**Subject:** Eagle Rising SF2225 Plat Filing No. 1 - Two Unresolve comments

In addition to Duncan Bremer's August 22<sup>nd</sup> e-mail to Meggan, I thought it would be good to follow up with both of you. Except for two unresolved comments the other EPC review staff comments will be addressed and uploaded to EDARP. The request to have lot lines adjusted to be a minimum of 15' from the 100-year water surface line and the Kurie Road ROW request are addressed herein to satisfy the requirements for administrative approval of the Eagle Rising SF2225 Plat Filing No. 1.

EAGLE RISING FILING NO. 1
 A PORTION OF THE EAST HALF (E 1/2) OF SECTION 29, TOWNSHIP 12 SOUTH,
 RANGE 65 WEST OF THE SIXTH PRINCIPAL MERIDIAN, EL PASO COUNTY, COLORADO

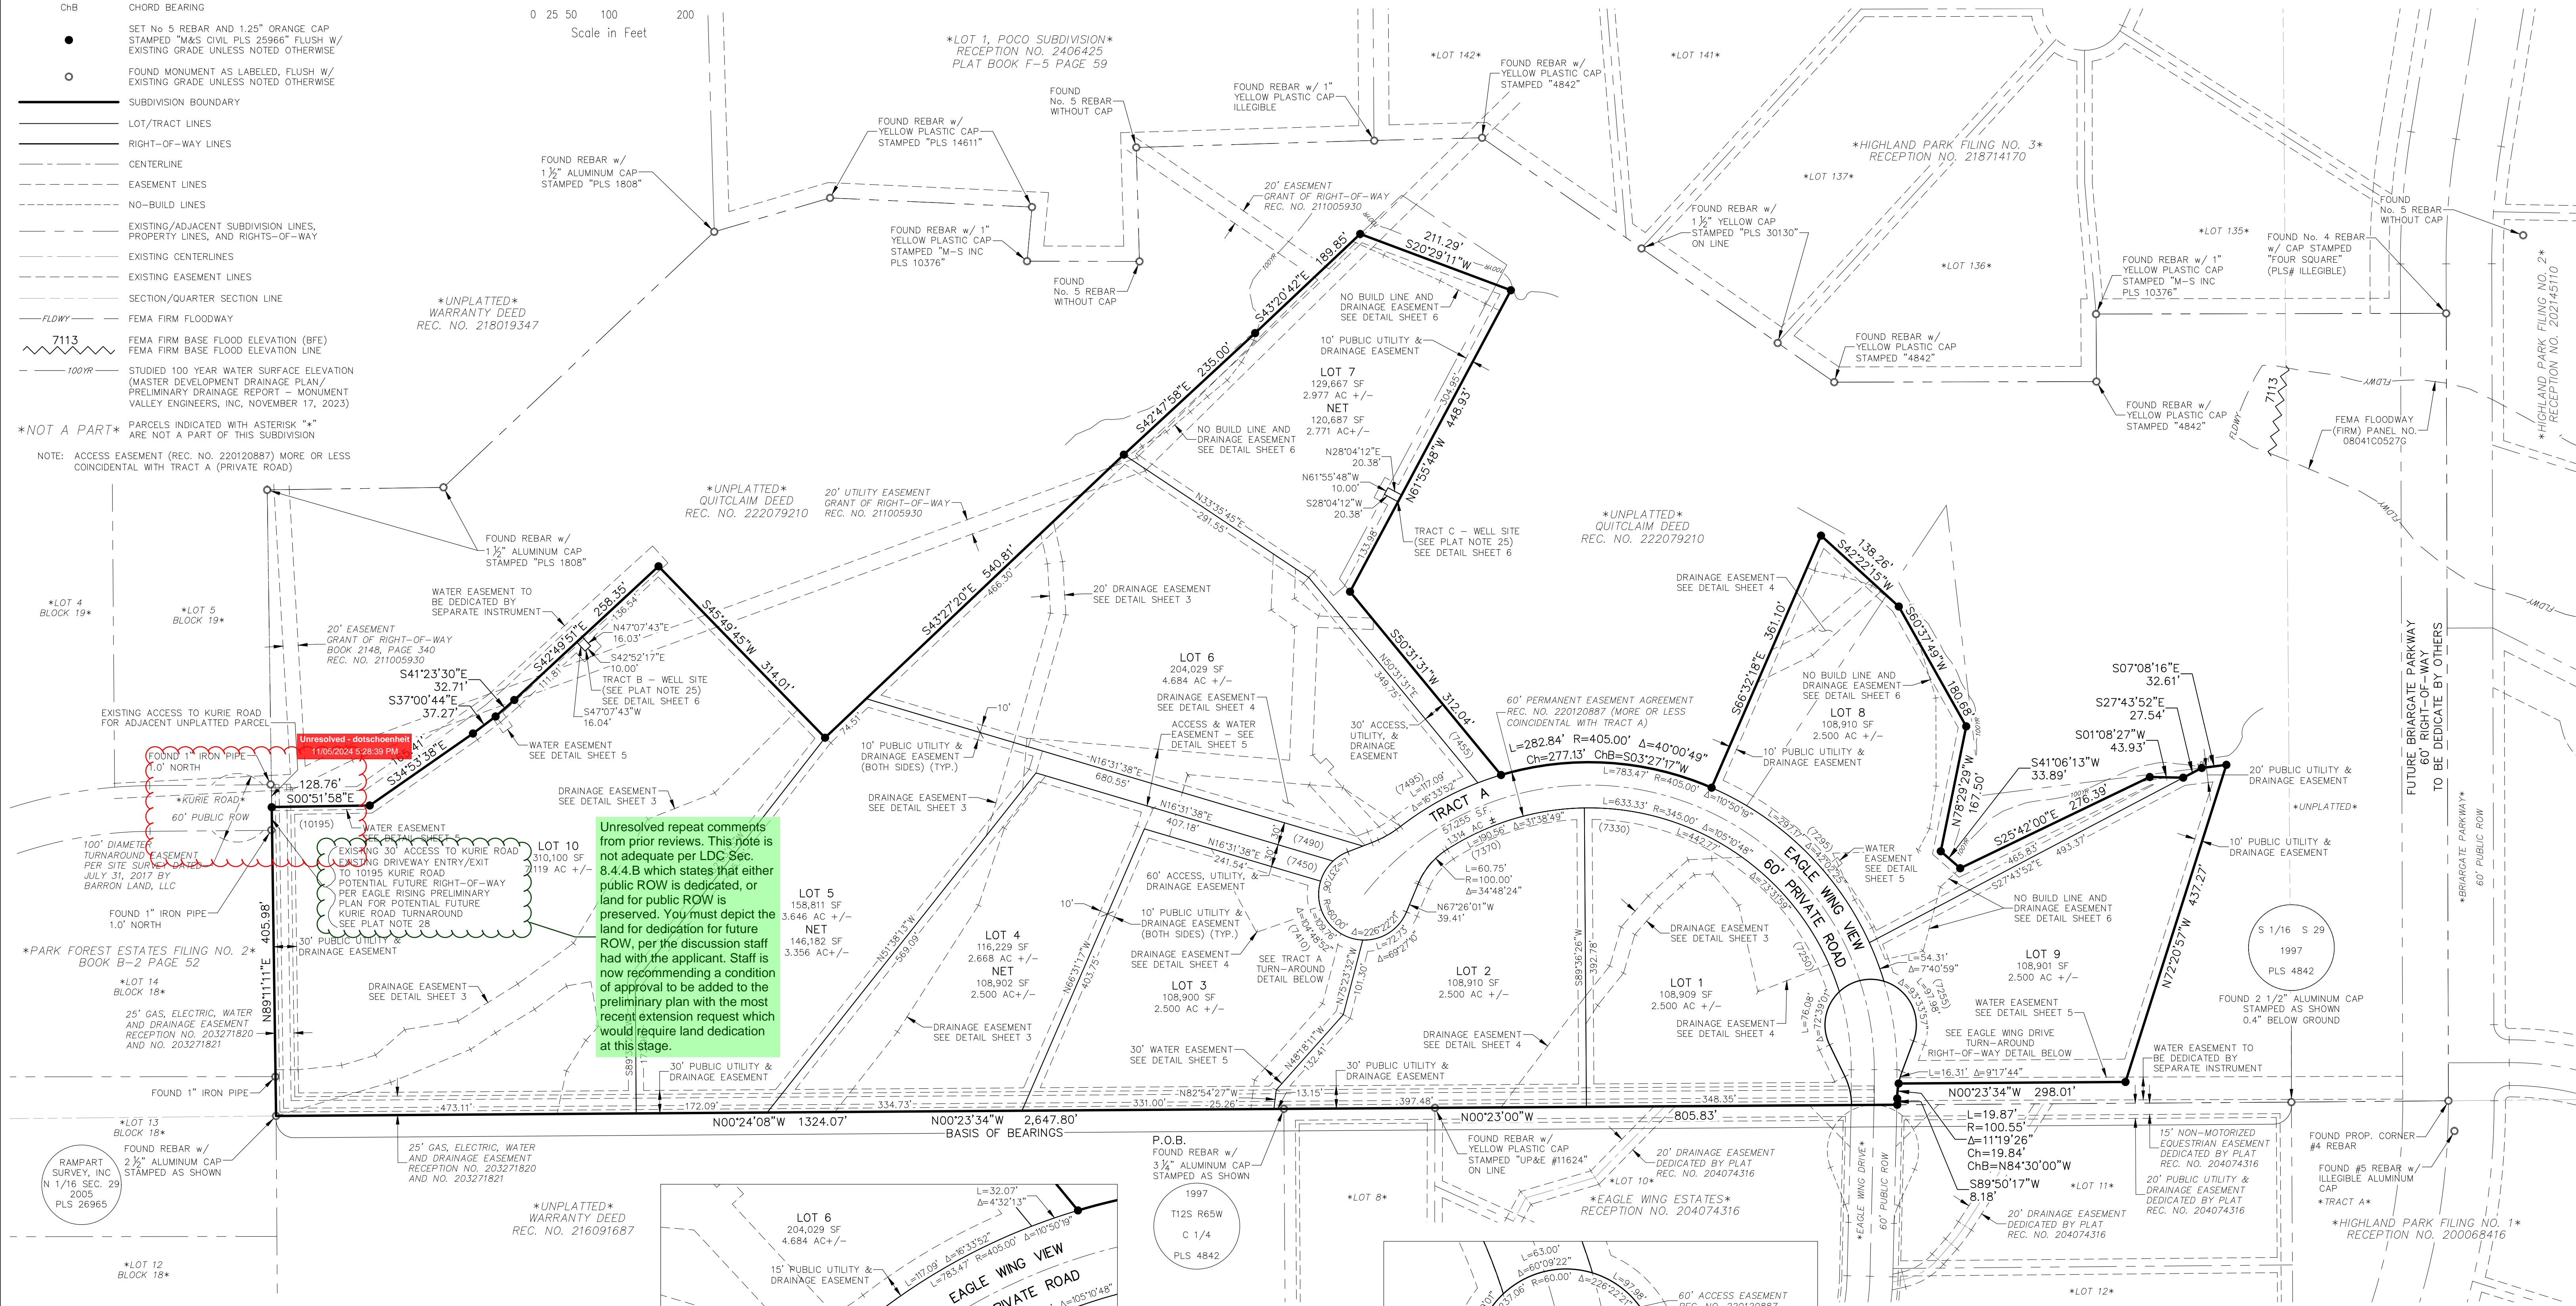
An addition to the note regarding Kurie Road as shown in blue below on the extract from the Plat to satisfy LDC Section 8.4.4.B will be added to the Filing No. 1 Plat.

**STUDIED 100 YEAR WATER SURFACE ELEVATIONS
 NO-BUILD LINE AND DRAINAGE EASEMENT DETAIL**
 LOTS 6 & 7
 SCALE: 1" = 50'

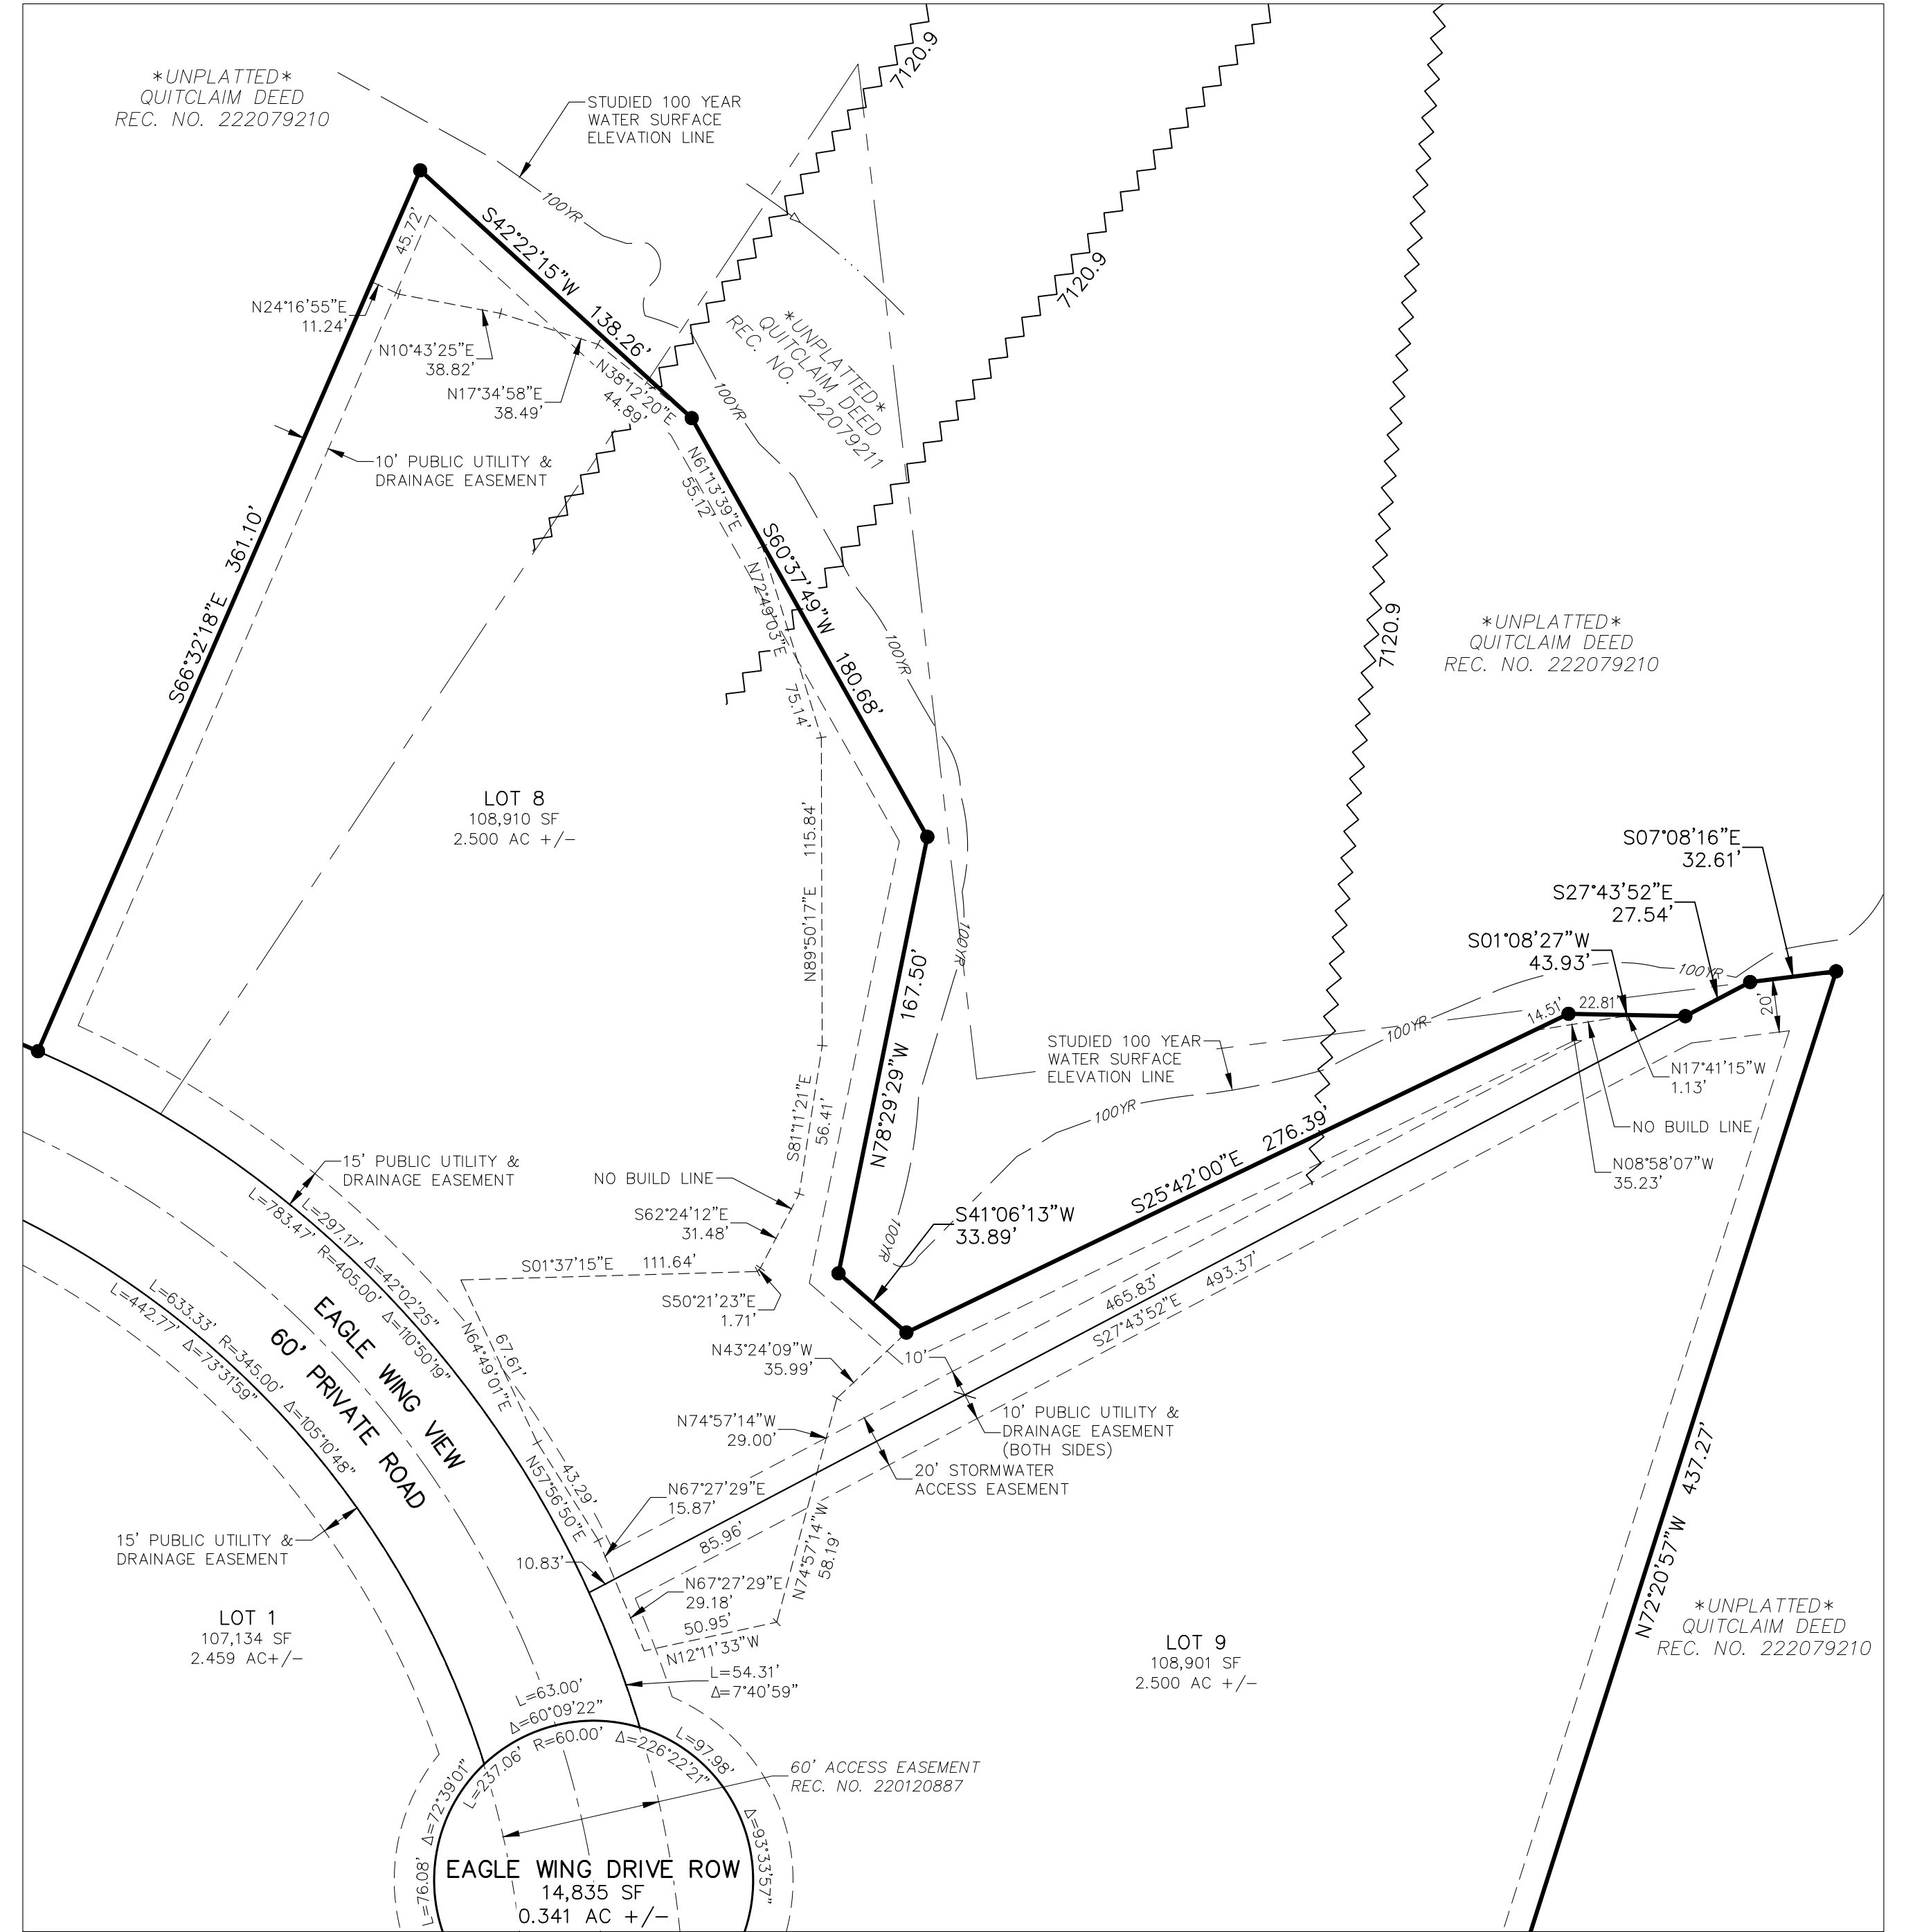
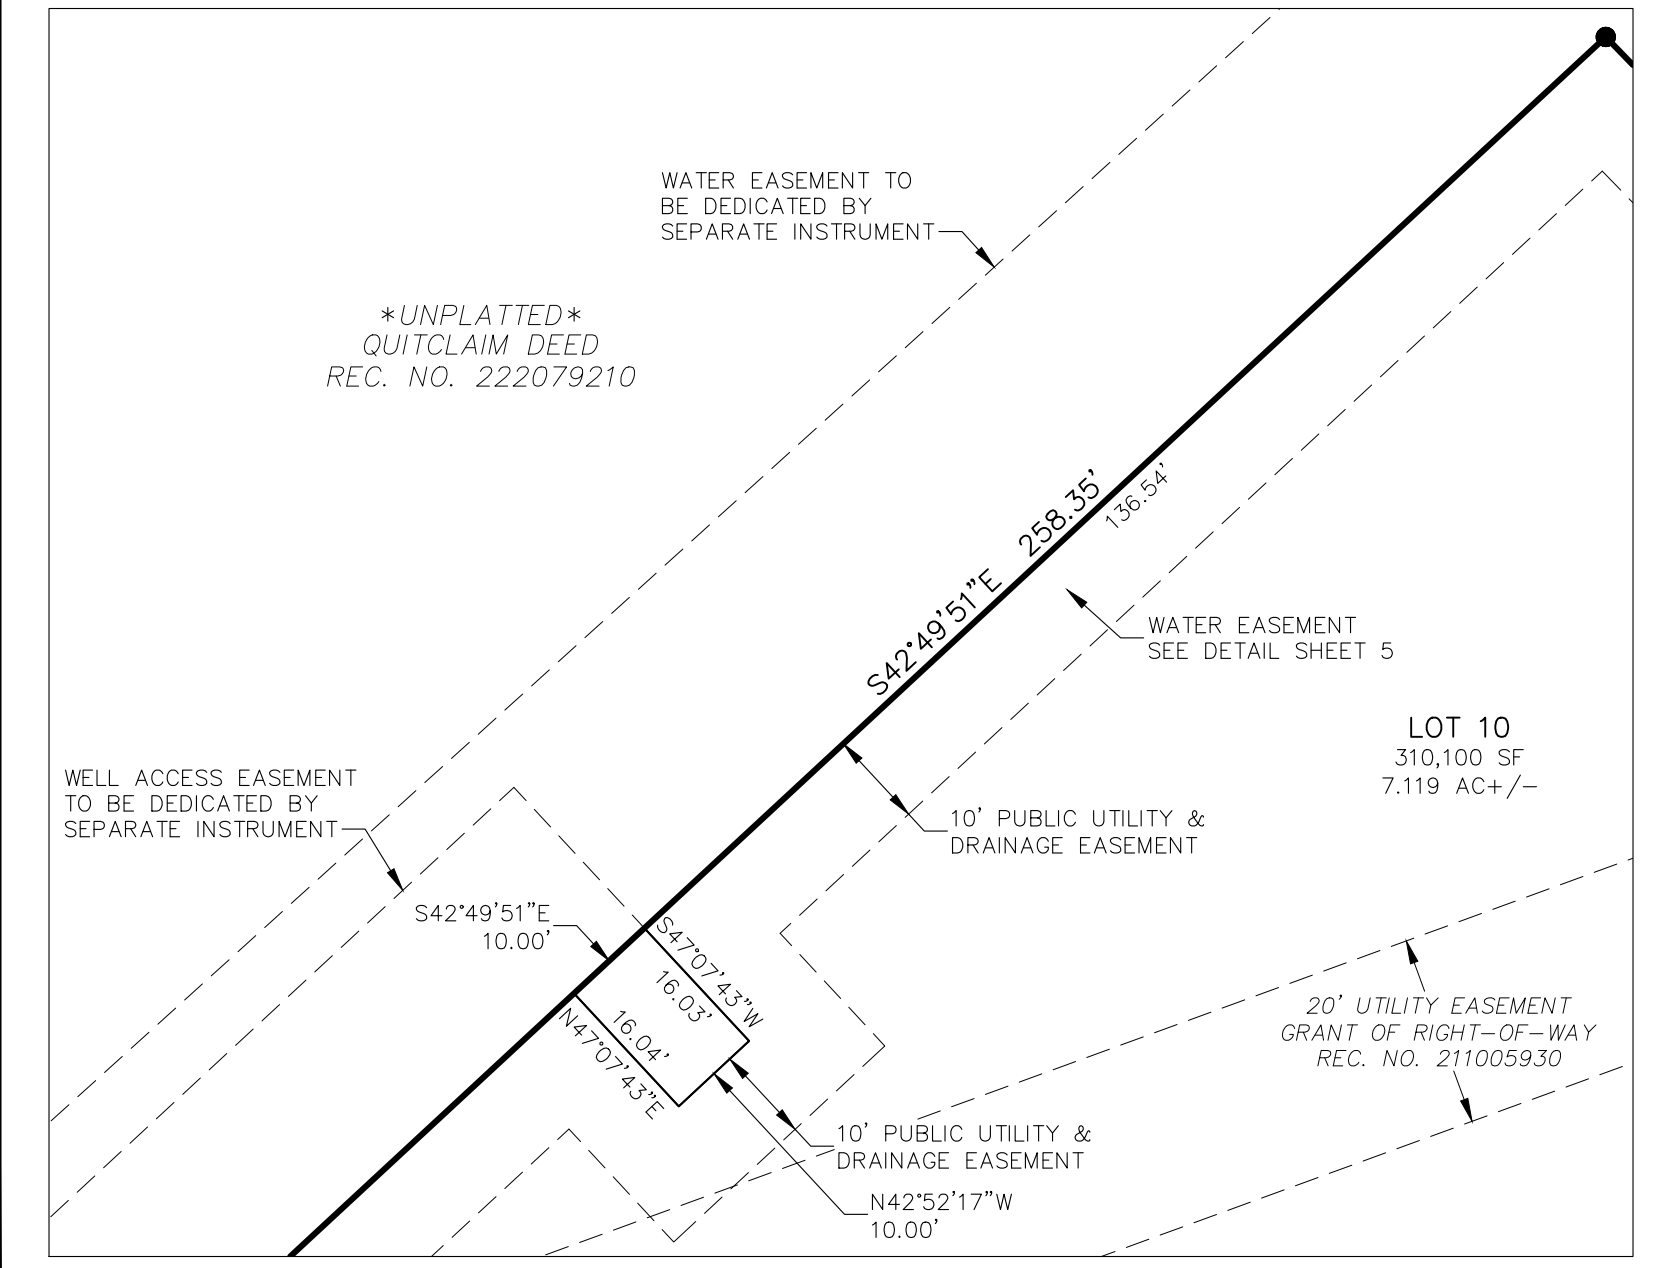
- However, as noted the EPC review engineers are requesting that the Lot 7, 8, and 9 Lot property lines be adjusted to be a minimum of 15' from the 100-year water surface line. Considering the 10' easement and the Access to the Creek Exhibit there is no rational engineering basis for this additional 15' to further reduce the size of the Lots. Also, there is no justification for adding access along the back side of the Lots for access to the Creek.

- As previously discussed, lot property lines will be adjusted between CASA LP #4 and IQ Investors, LLC prior to filing the Plat to move Lots 7, 8 and 9 out of the 100-year water surface elevation for Eagle Rising Filing No. 1. This, as you agreed, eliminates the need for a maintenance agreement for Cotton Wood Creek for Filing No. 1. There is no justification for the request that the lot lines be 15' from the 100-year water surface elevation line.

- Furthermore, the No Build and Drainage Easement Lines shown on the Plat, (highlighted in red below), are 2' above the 100-year water surface elevation even further away from the 100-year line out of an abundance of caution vs. only 1' as require for a FEMA Floodplain. NOTE: The 100-year water surface is not classified as a FEMA Floodplain.
